<b>Application Ref:</b>	3/2025/0891			 Ribble Valley Borough Council <a href="http://www.ribblevalley.gov.uk">www.ribblevalley.gov.uk</a>				
<b>Date Inspected:</b>	25/11/25	<b>Site Notice:</b>	N/A					
<b>Officer:</b>	LW							
<b>DELEGATED ITEM FILE REPORT:</b>					<b>APPROVAL</b>

<b>Development Description:</b>	Proposed first-floor rear and side extension and internal alterations.
<b>Site Address/Location:</b>	18 Rogersfield, Langho, BB6 8HB.

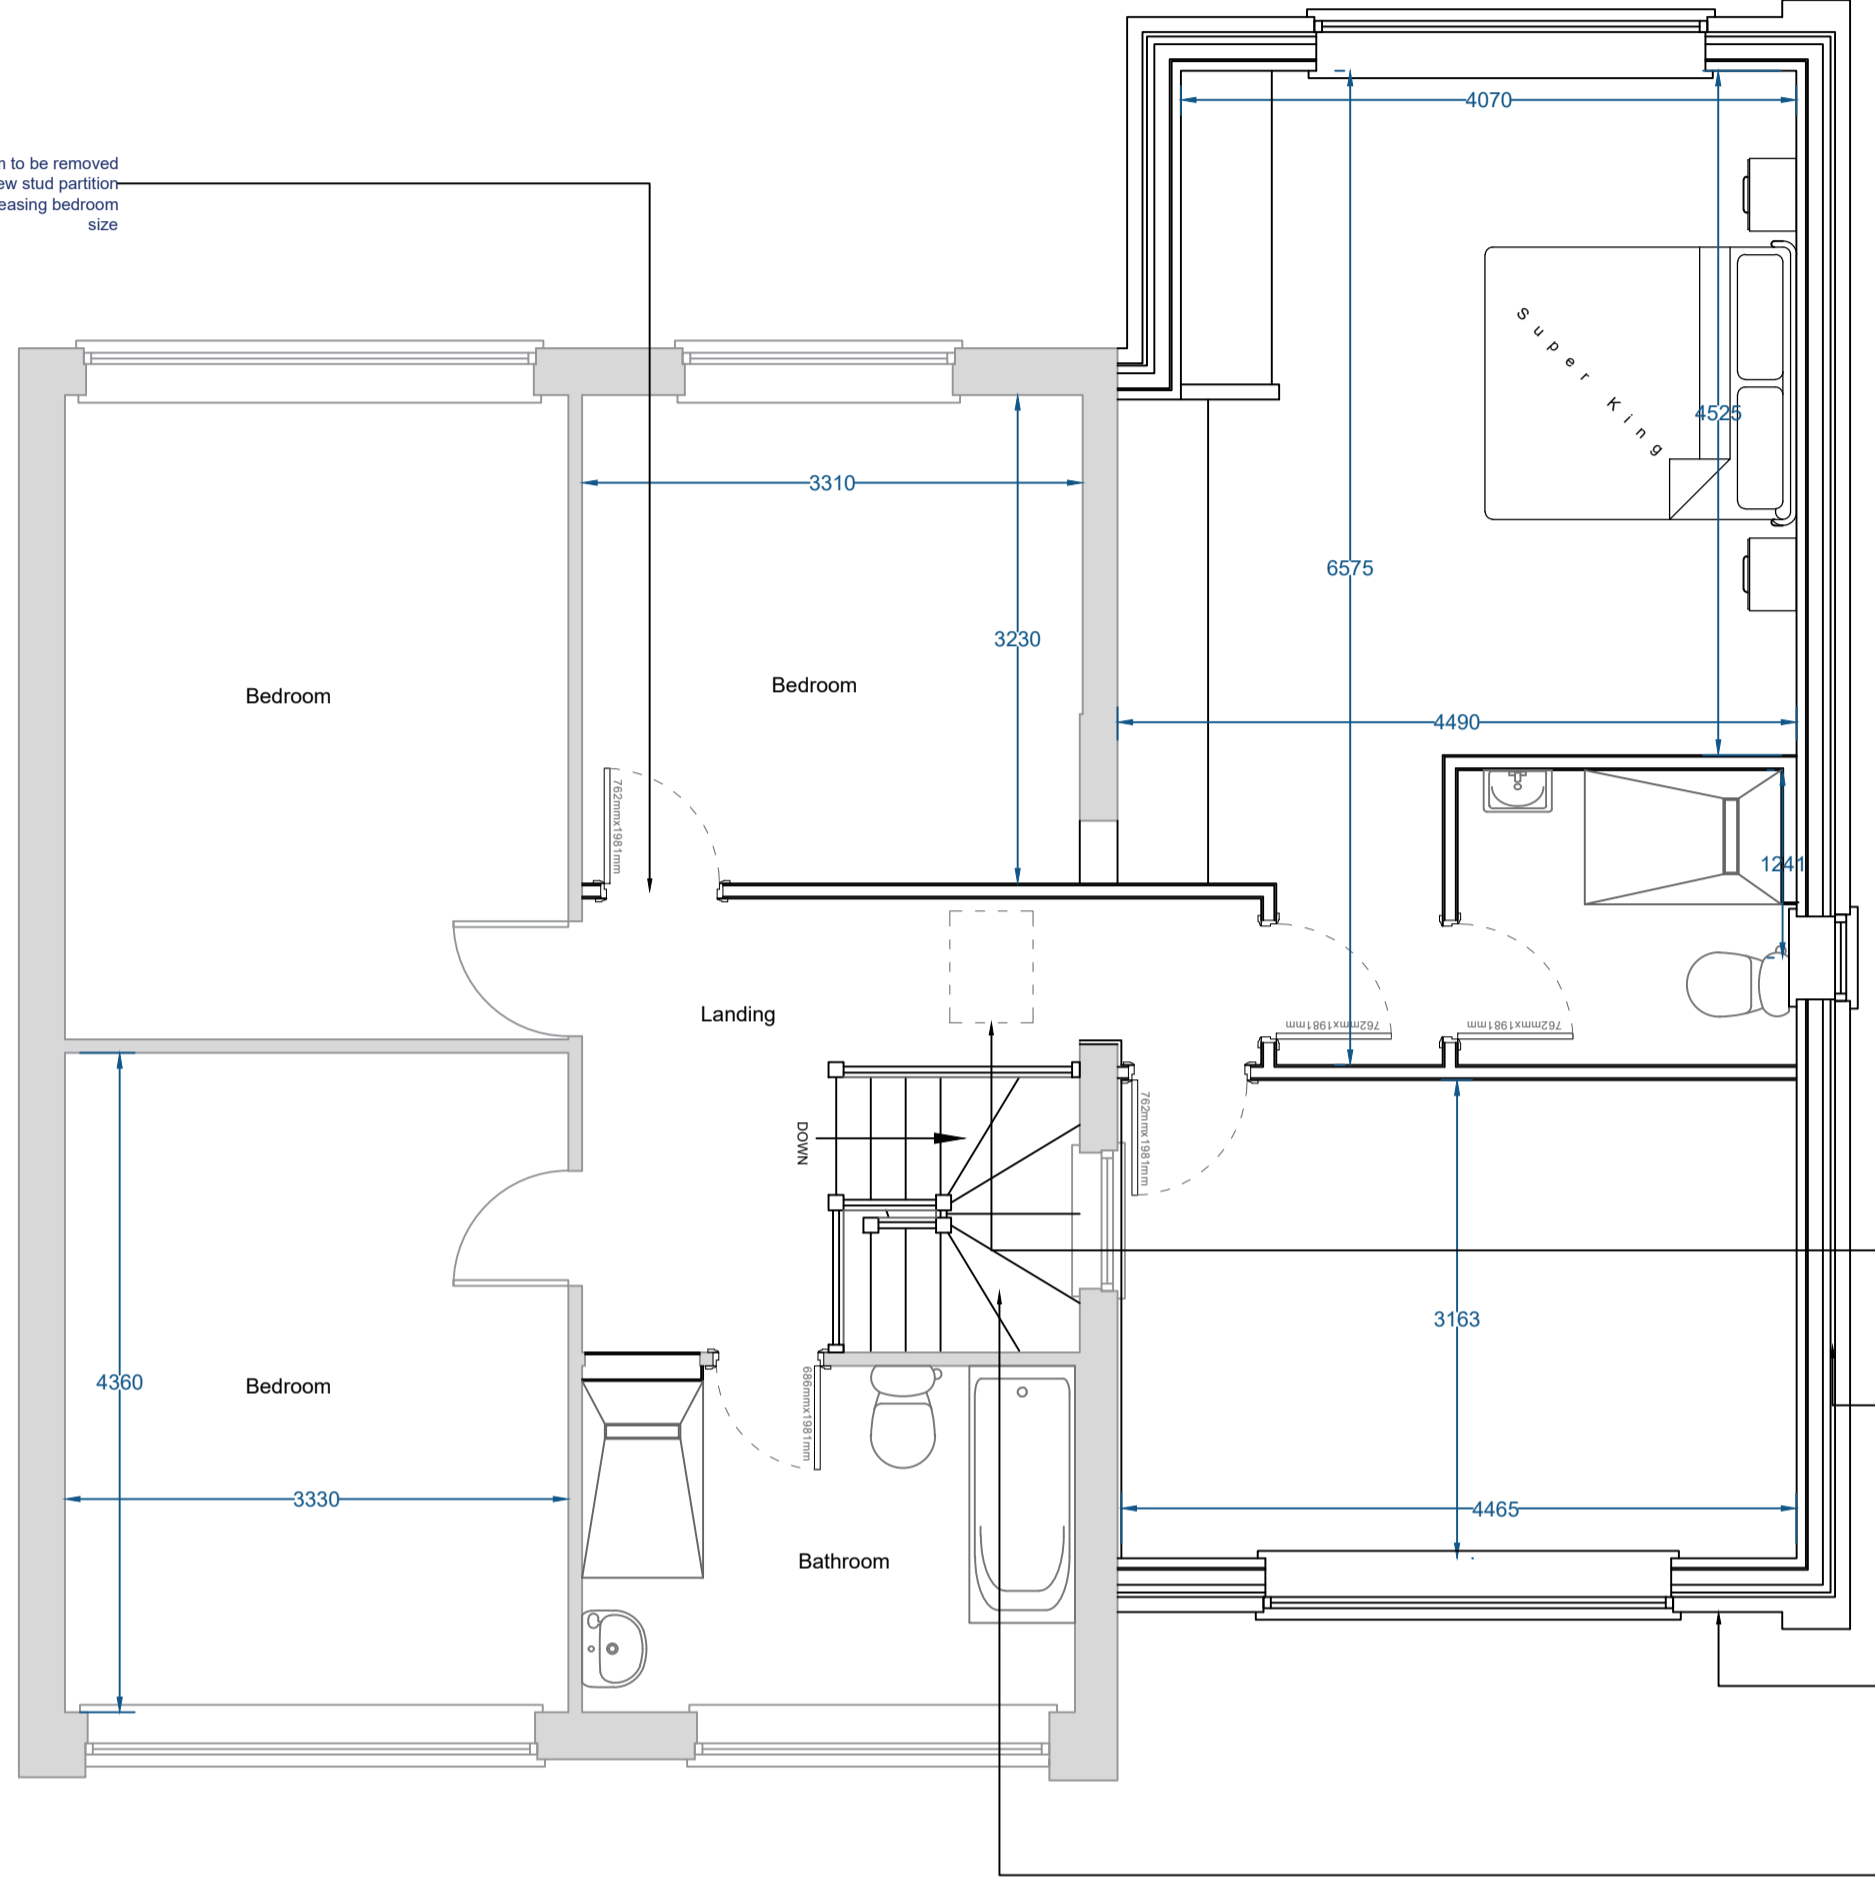
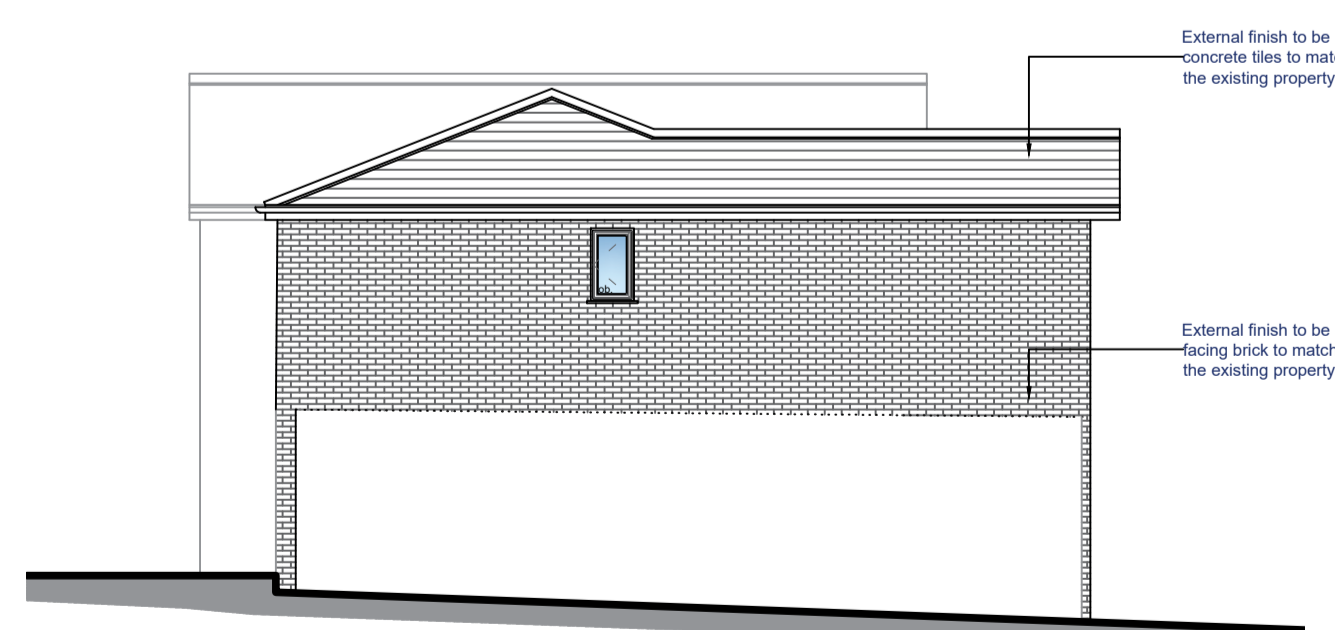
The scheme as originally submitted incorporated a gabled roof form. However, following discussions with the agent, this has been amended to a hipped roof form in order to reduce the volume that would be incorporated at roof level and minimise the overall bulk and massing of the development. The revised scheme would also appear better related to the existing two-storey side extension featured to the north-eastern elevation of No.16 Rogersfield, which also incorporates a hipped roof, further minimising the impact of development upon the street scene. The proposed materials are also considered acceptable, insofar that they would match the external appearance of the application property and surrounding built form.

The proposal will increase the number of bedrooms within the dwelling from 4 to 5 and amend the off-street parking provisions by reducing the existing garage. The recommended minimum internal dimensions for a single garage size are 6m in length and 3m wide. As the proposed garage will be smaller than the recommended internal dimensions, it cannot be considered to provide off-street parking provisions. However, given the size of the existing driveway, the Local Highway Authority (LHA) consider it likely to accommodate three off-street parking spaces which meets the parking requirements for a 4+ bedroom dwelling.

As a result of this, the LHA are of the opinion that the proposal would not have a significant impact upon highway safety or capacity in the immediate vicinity of the site.
